**RE: APD Crime Paving Improvements
5203 2nd St. NW
Grading and Drainage Plan
Engineer's Stamp Date: 6/16/2022
Hydrology File: F15D019A**

Based upon the information provided in your submittal received 6/16/22, the 2nd Revised Grading and Drainage Plan is approved for Grading and Building Permit.

**RE: APD Crime Lab Paving Improvements
Hydrology File: F15D019A**

TITLE: GRADING PLAN	
Design Review Committee	City Engineer
City Project No.	Zone Map No.
-	F-15-Z
Sheet	Of
4	12

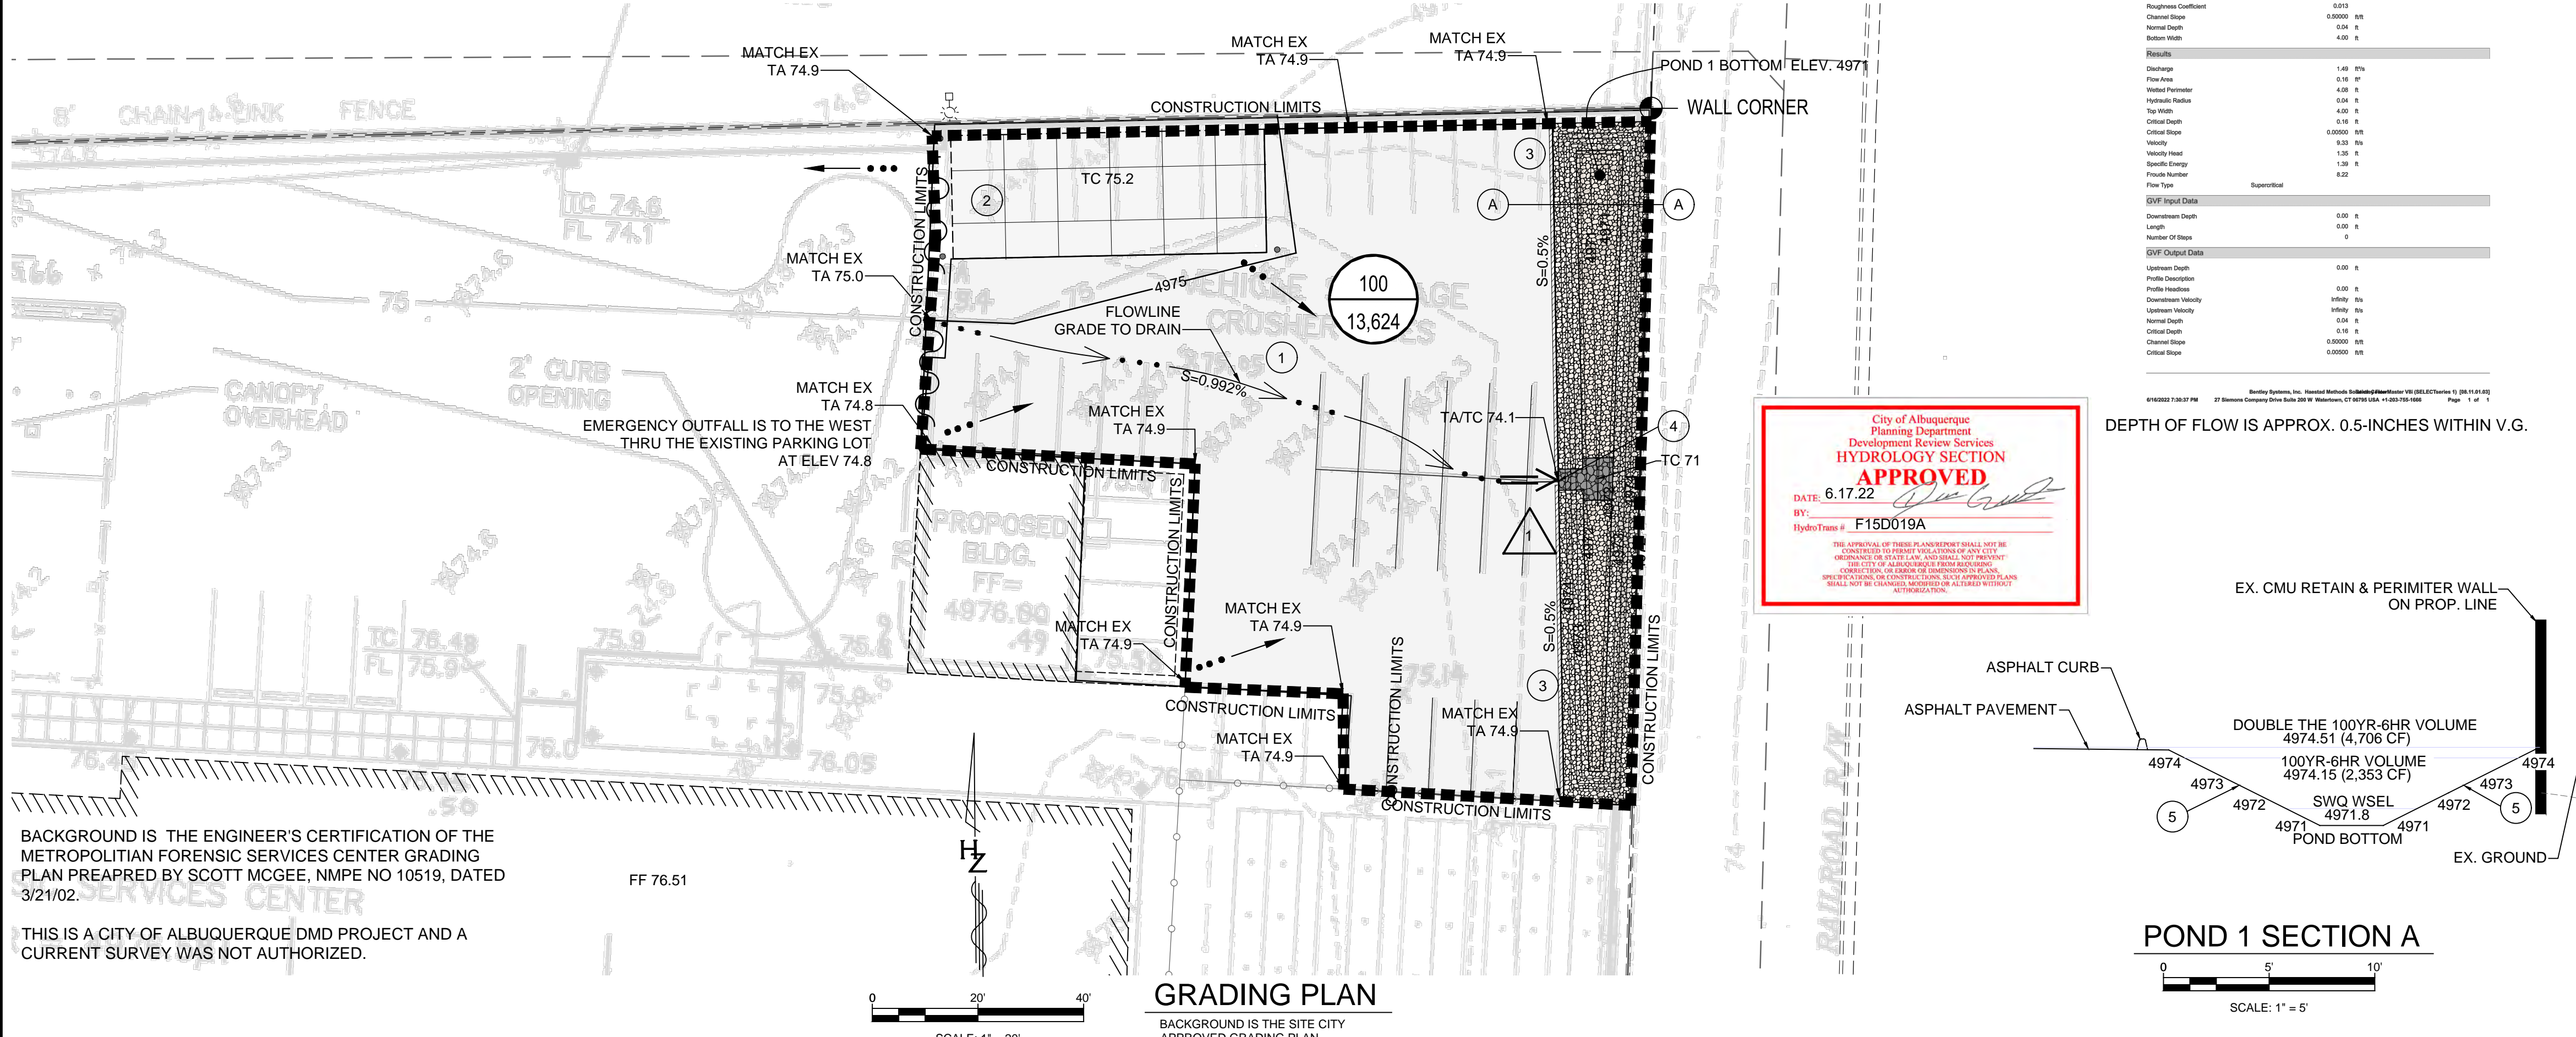
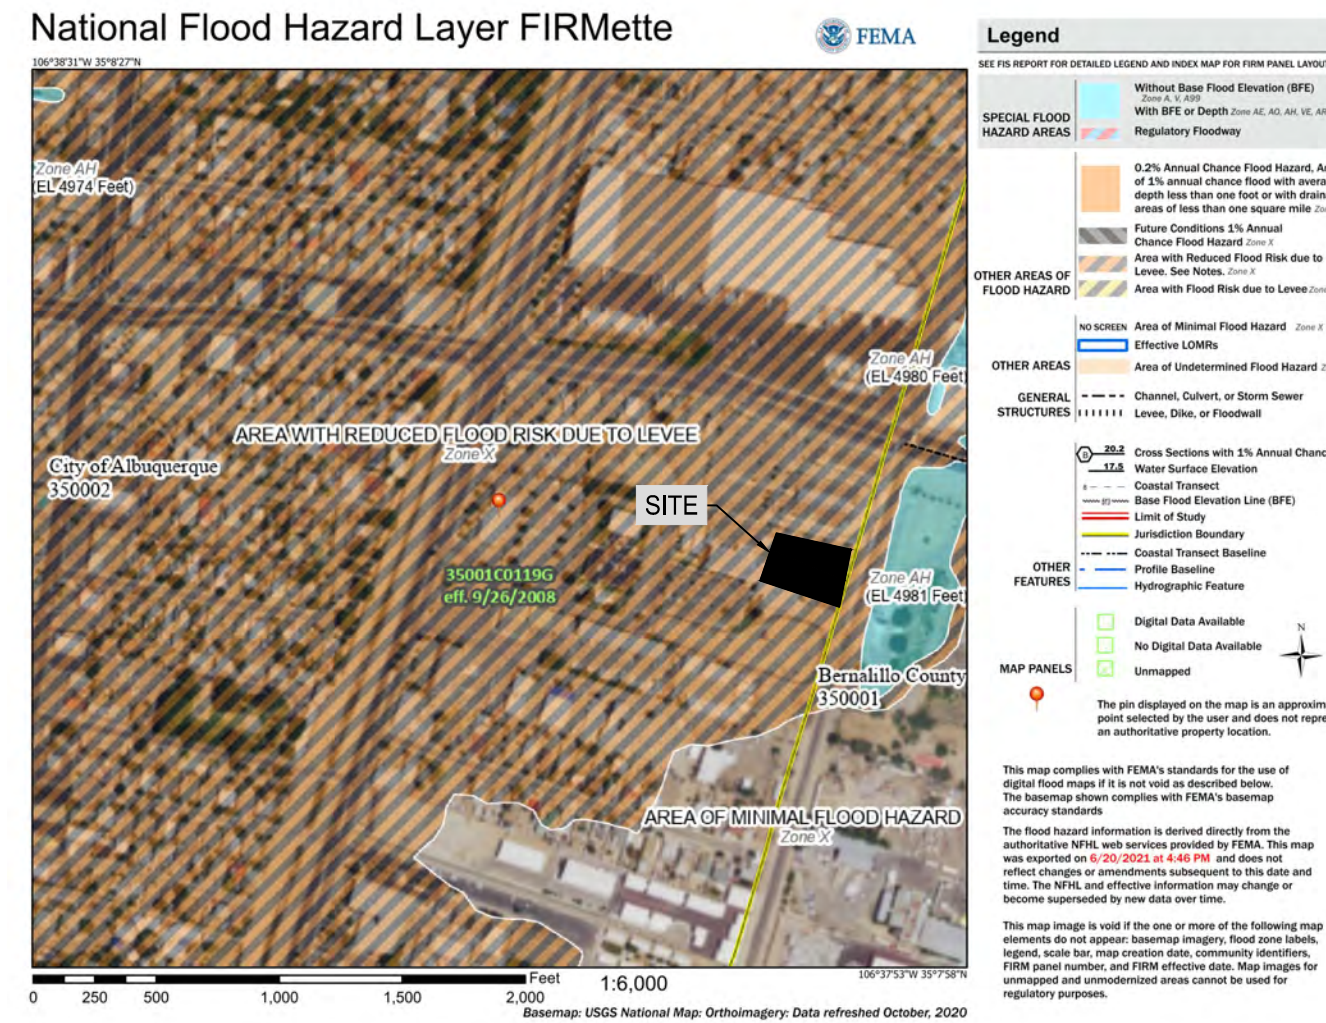
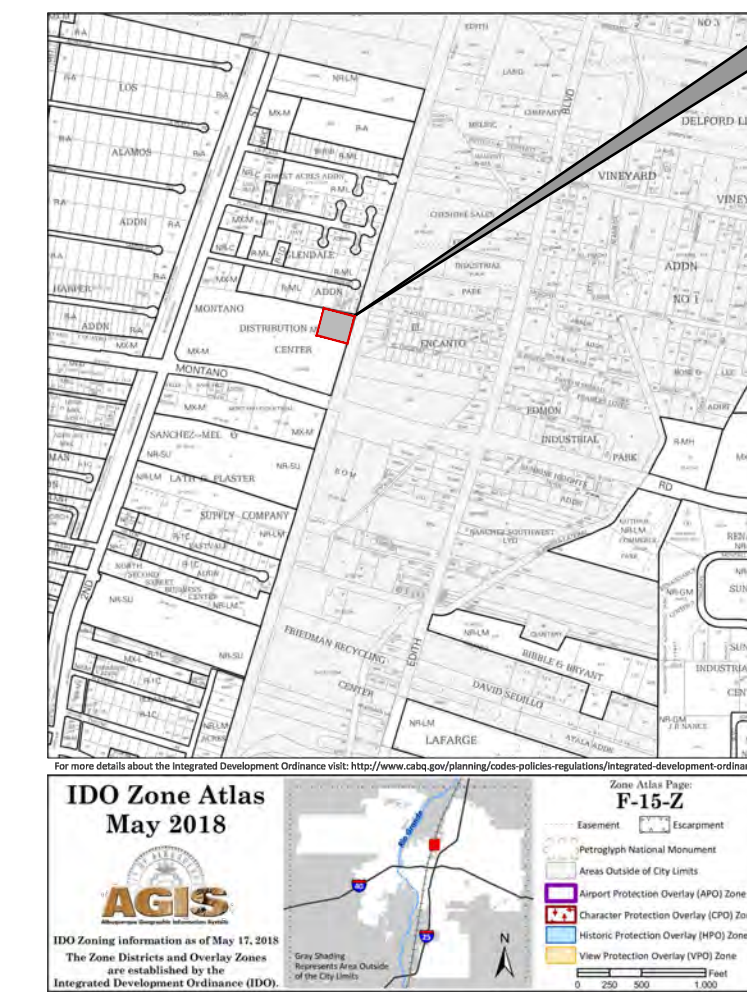
1. *Please use a 1:20 scale.*
Plan View Revised to 1:20.
2. *Please fade back the existing G&D copied over and make it clear with a note that it is present and is for informational purposes.*
Existing G&D faded and a note added in lower left hand corner of plan view.

3. *Please clearly define the basin boundary as the area defined for construction limits of the proposed G&D.*
Construction Limits labeled along boundary.

4. *Please provide a section of the pond and provide elevations (100 year storm, outlet elevation, SWQV elevation, bottom, etc...)*
Section A added on the right corner of the plan containing the requested information.

5. *Please Clearly*
No Response
6. *Please clarify elevation labels and illustrate outfall.*
Labels have been edited for clarity – pond does not discharge.

7. *Please clearly show keyed note 4.*
 - a. *Note 4 is obscured by hatching.*
Hatching is lightened and key note 4 is moved outside of pond.
 - b. *Are there calculations showing the wier opening? Please demonstrate how it will handle the flow going into the pond.*
Calculations Added.

- c. *Provide construction detail of rundown.*
Added reference to City Standard Drawing 2422 with construction note.
8. *Please clearly show a graphic of where pond will discharge.*
Pond does not discharge.

9. *Will there be a curb and gutter on this parking lot or simply edge of pavement? It is unclear the transition and if there is a flowline to get the flow to the rundown.*
Project includes an asphalt curb adjacent to the pond and a flowline within the pavement is now shown.

10. *Please provide benchmark coordinates and tie to the construction limits to the benchmark.*
Reference to City Benchmark provided on left side of plan tie not shown as City DMD did not authorize a project survey.

11. *Please include datum reference.*
Datum reference provided on left side of plan.
12. *Please note this is a retention pond but note where emergency outfall will be.*
Emergency outfall is back thru the existing parking plot to the west.
